Consultation Response from KC, Lead Local Flood Authority
2023/93236 Pentlands, New Mill Road, Holmfirth, HD9 7LN
Discharge conditions 4 (Internal Estate Road Details), 5 (Parking Bay Surfacing & Drainage), 9 (Temporary Waste Measures), 11 (Surface Water Drainage Details), 12 (Overflow Event Scenario), 13 (Separate Forms of Drainage Details), 15 (Temporary Drainage Measures), 22 (Ecological Enhancement Plan) on previous permission 2020/91896 for demolition of existing dwelling and erection of 15 dwellings with associated access and external works
Date Responded: 12th March 2024 Responding Officer: Paul Farndale Responding Ref:

Condition 11 – Drainage Details

SECTION C-C
SW3 - SW9 - SW8 - SW5 - LONGSECTION
176.000m AOD, SCALE : H 1:250, V 1:50

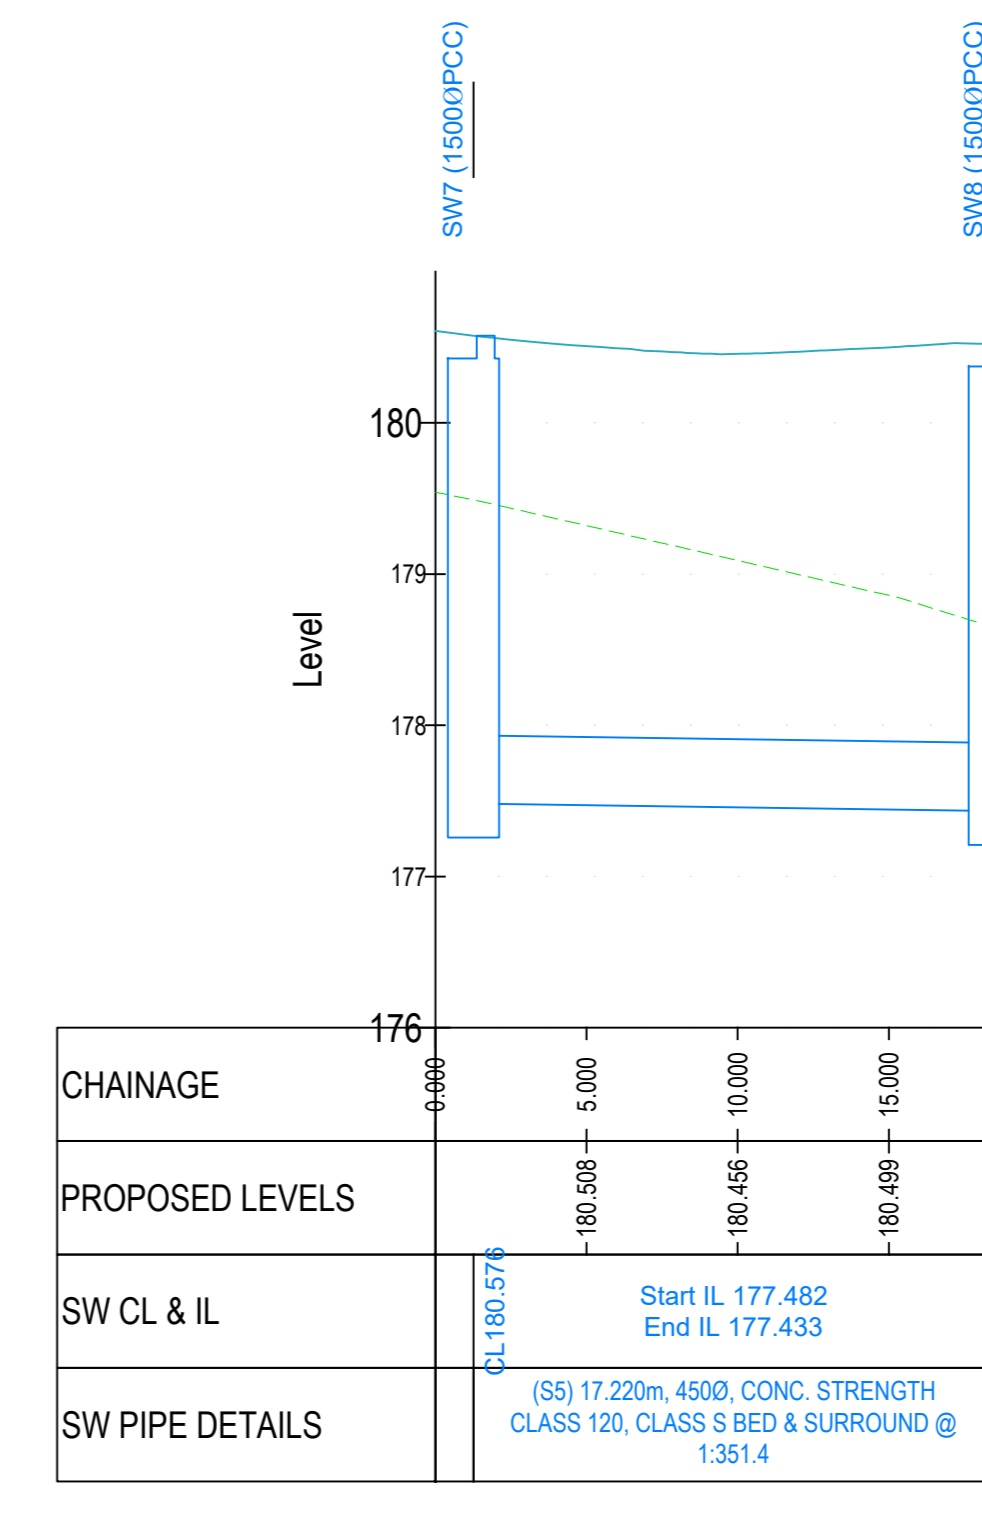
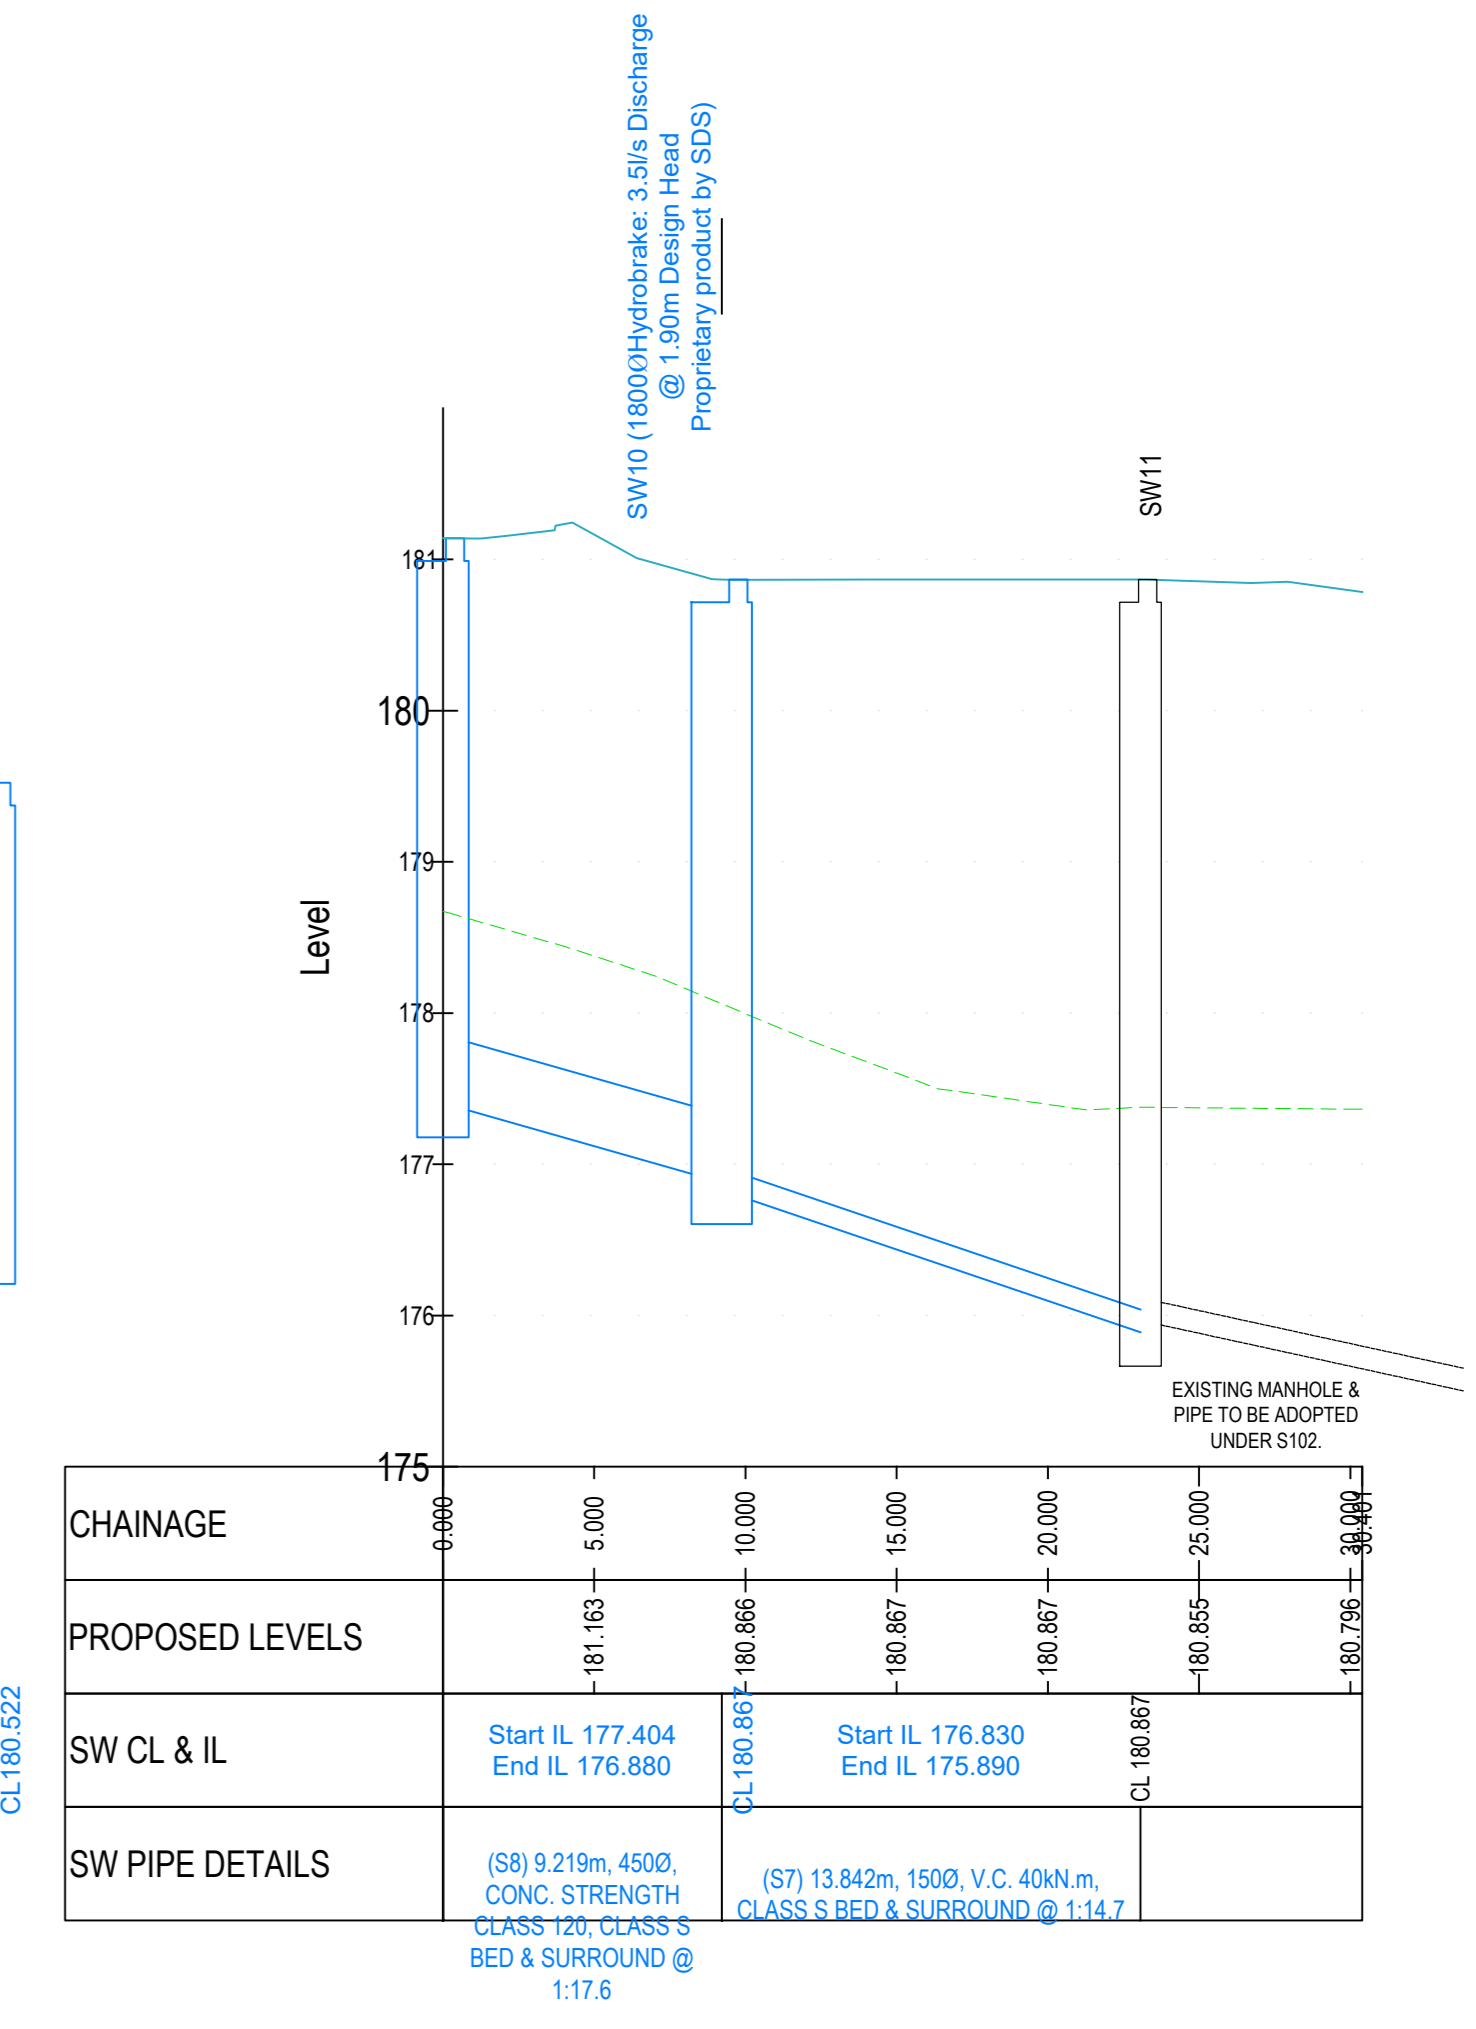
Off-site works are now shown with longitudinal sections. The adjacent site has a temporary outfall and therefore the connection can be made.

File: Proposed S104 Drainage Layout

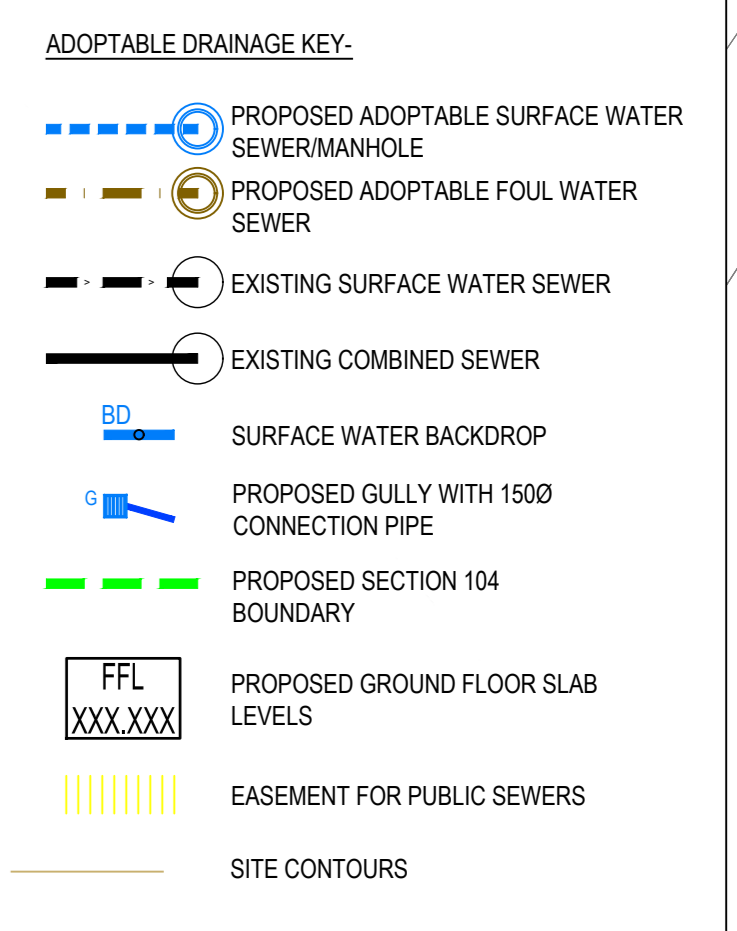
Details of the tank design including invert and cover levels has been provided. However, this is contrary to what was discussed for planning application 2020/91896 which allowed approval subject to condition. At this point the application went forward with pre-cast concrete tank having been agreed. This principle has been reneged upon

Kirklees Council will only accept the tank as designed if a technical approval letter from Yorkshire Water can be produced under section 104 of the Water Industry Act that will satisfy the LPA that their obligations to ensure maintenance and management of a structure for the lifetime of the site can be passed onto a recognised statutory undertaker. Such designs cannot be inspected and carry no guarantee on lifespans.

As an additional note, the calculations provided are for a different sized tank than submitted on the plan. No allowance for void ratio has been included.
